From: Amanda Scholes on behalf of Planning.Responses
Sent: 09 March 2018 08:28
To: Planning Scanning
Subject: FW: 3 The Street, East Preston, BN16 1JJ

Please can this be scanned against application EP/159/17/DOC as additional correspondence

I have discussed this with Juan. Whilst the first approved DOC EP/116/17/DOC relating to approval of screen walls and details reserved by condition did include note B this was not a detail being considered at that time. That part of boundary screening was not reserved by condition. This was clarified to the agent when the later DOC EP/159/17/DOC was submitted.

Drawing No. 217/536/6A

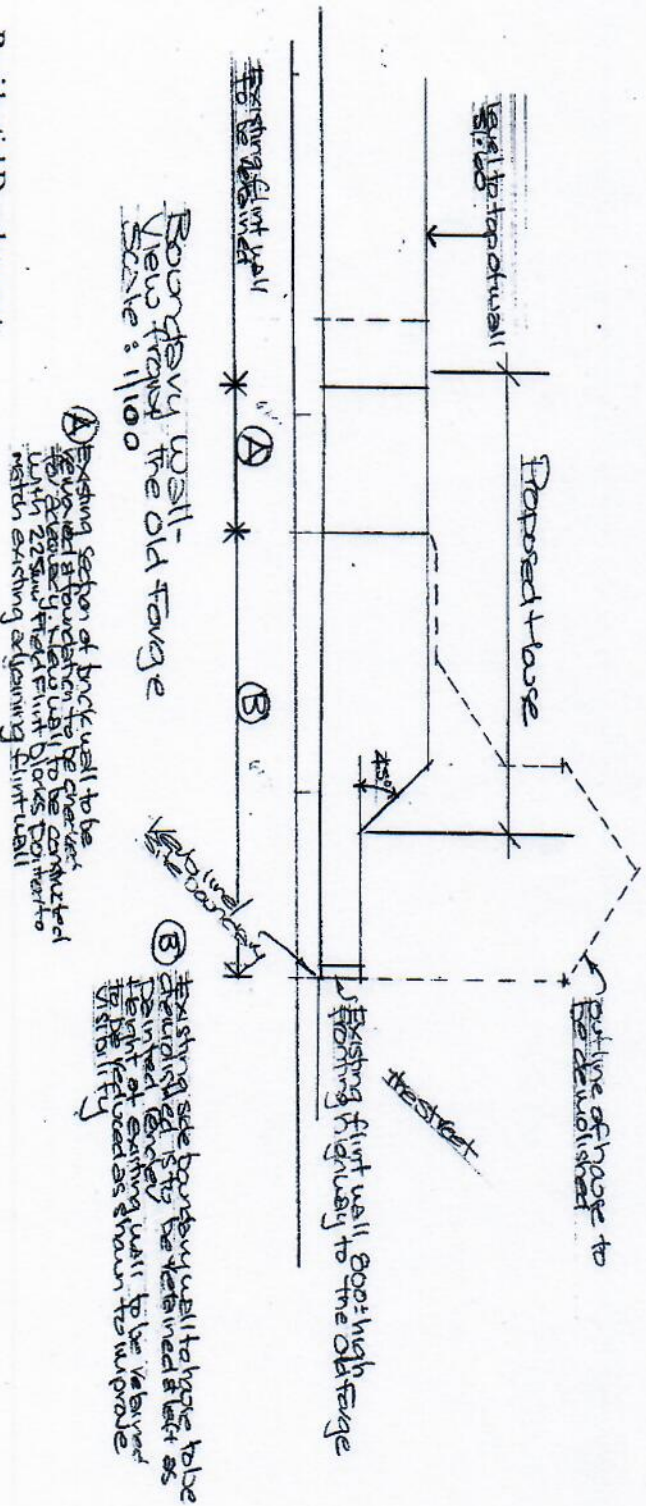
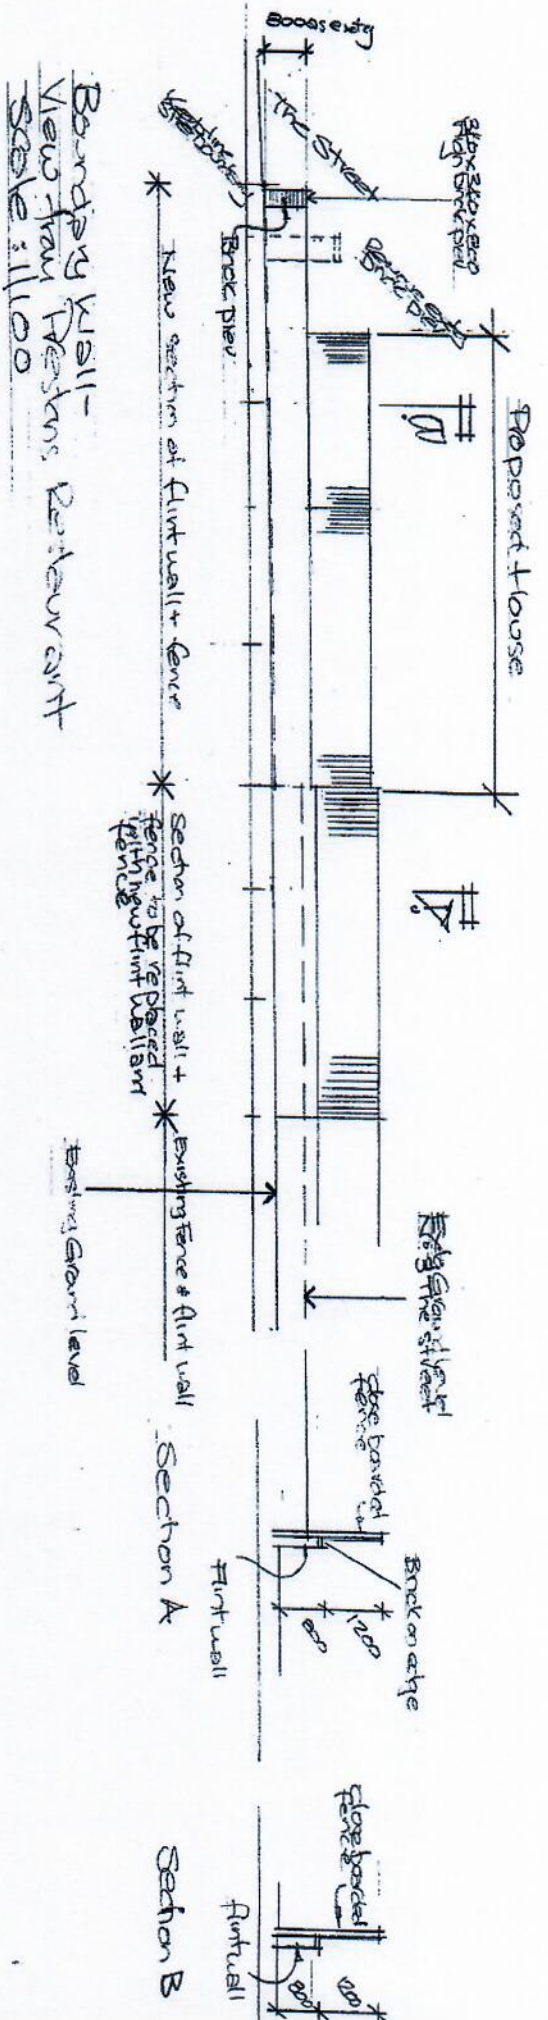
I propose the following response to Steve, but will first appreciate your thoughts on this as there appears to be some contradiction in ADC's approvals and reference to drawing 217/536/6A and in particular Note "B" on this drawing.

1. The attached coloured sketch which forms part of EP/146/15/PL which supports drawing 1549/2.02B, leaving drawing 217/536/6A Note B in complete contradiction.
2. Arun District Council letter of the 19th February saying the approved flint wall should be provided.
